Department of Transportation

I-25 / Palmer Ridge Rd.
CDOT / El Paso County

RE: Monument Ridge East - Rezone

The Traffic Impact Study for Monument Ridge East dated March 11, 2024 has been reviewed by a CDOT Traffic Engineer. Their comments follow:

Figure 1

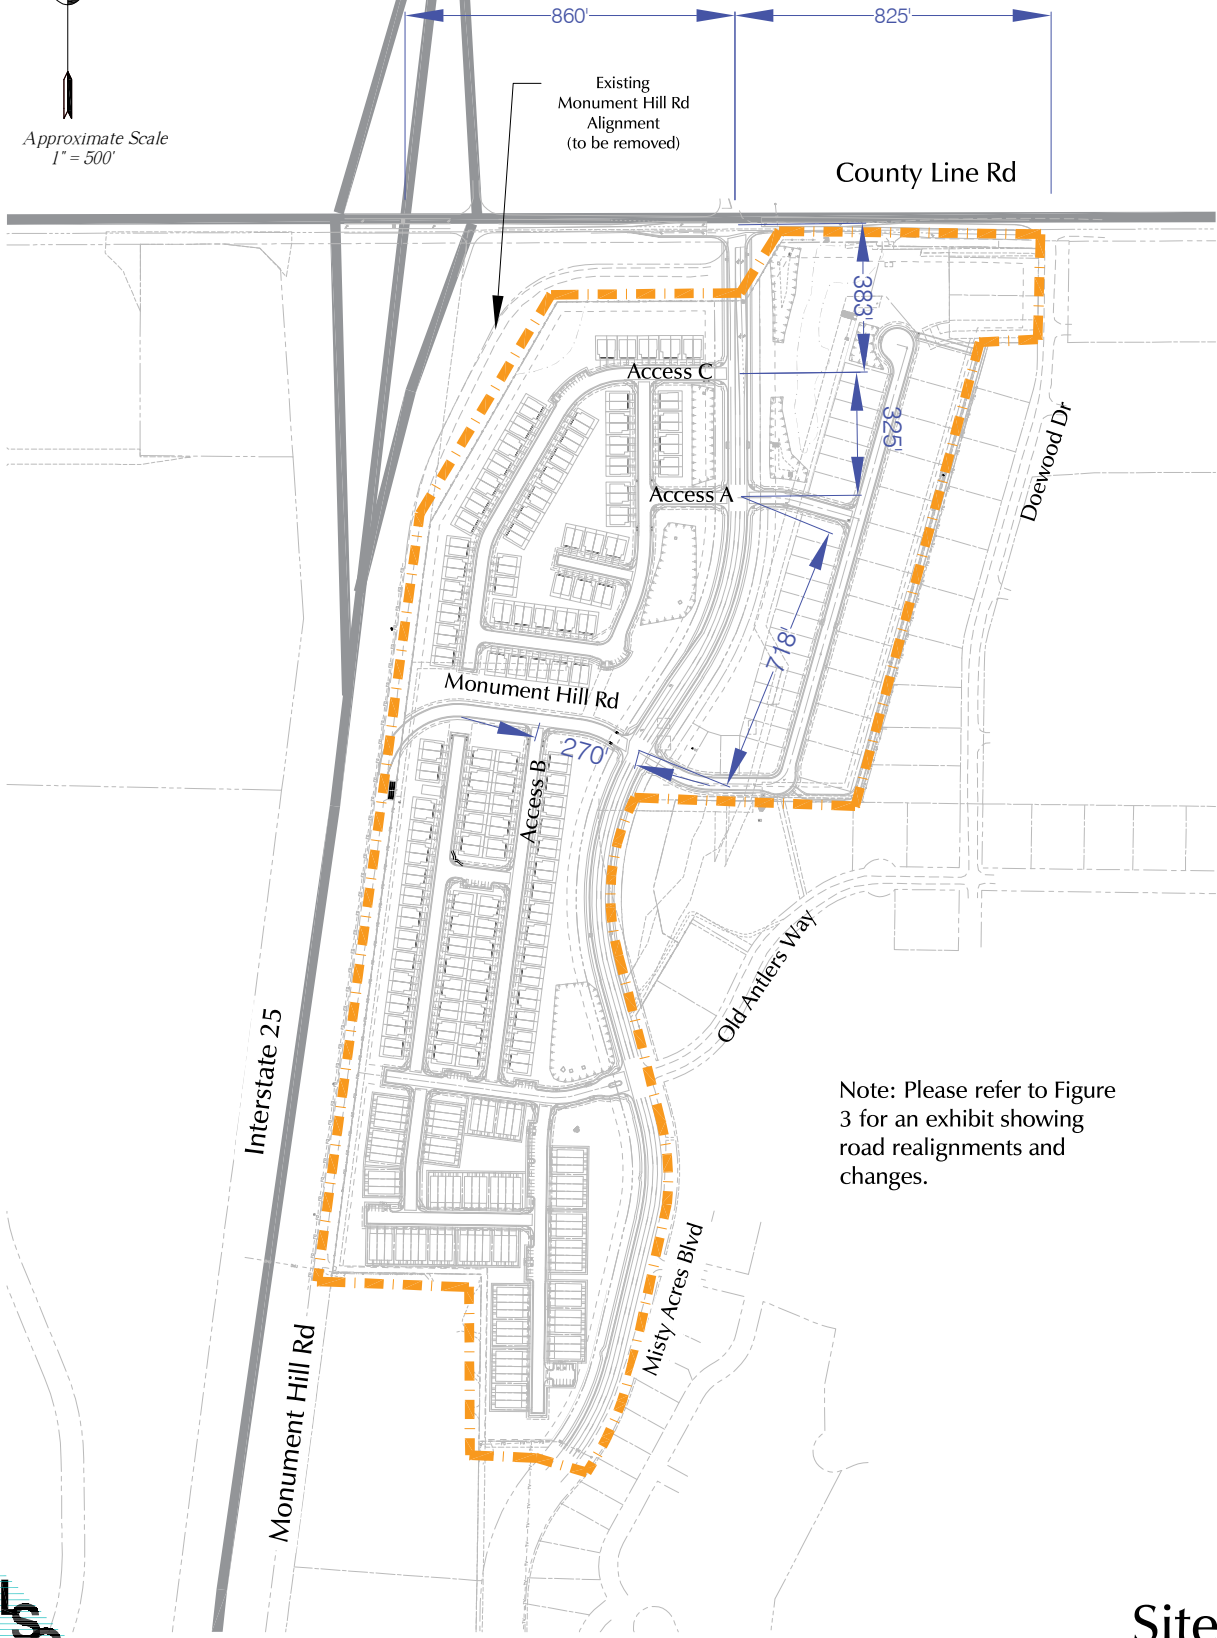
- Use ITE regression equations instead of average rates.
- Name Synchro LOS outputs to be consistent with intersection numbers used in Figures.
- Intersection #3 roundabout is evaluated as non-feasible in the future scenario due to terrain. The proposed development seems to be connected to Doewood Dr. So, the County Line Rd & Doewood Dr counts are needed, and this intersection will need to be modeled and analyzed in all scenarios.
- The closure of #3 access and conversion of County Line Rd @ Doewood Dr into a roundabout and a signal need to be considered.
- Intersection #3 (County Line Rd/Misty Acres) is proposed to be converted to a signal if/when warrants get met. The report also states that Warrant 2 is met for AM and PM peak hours so far.
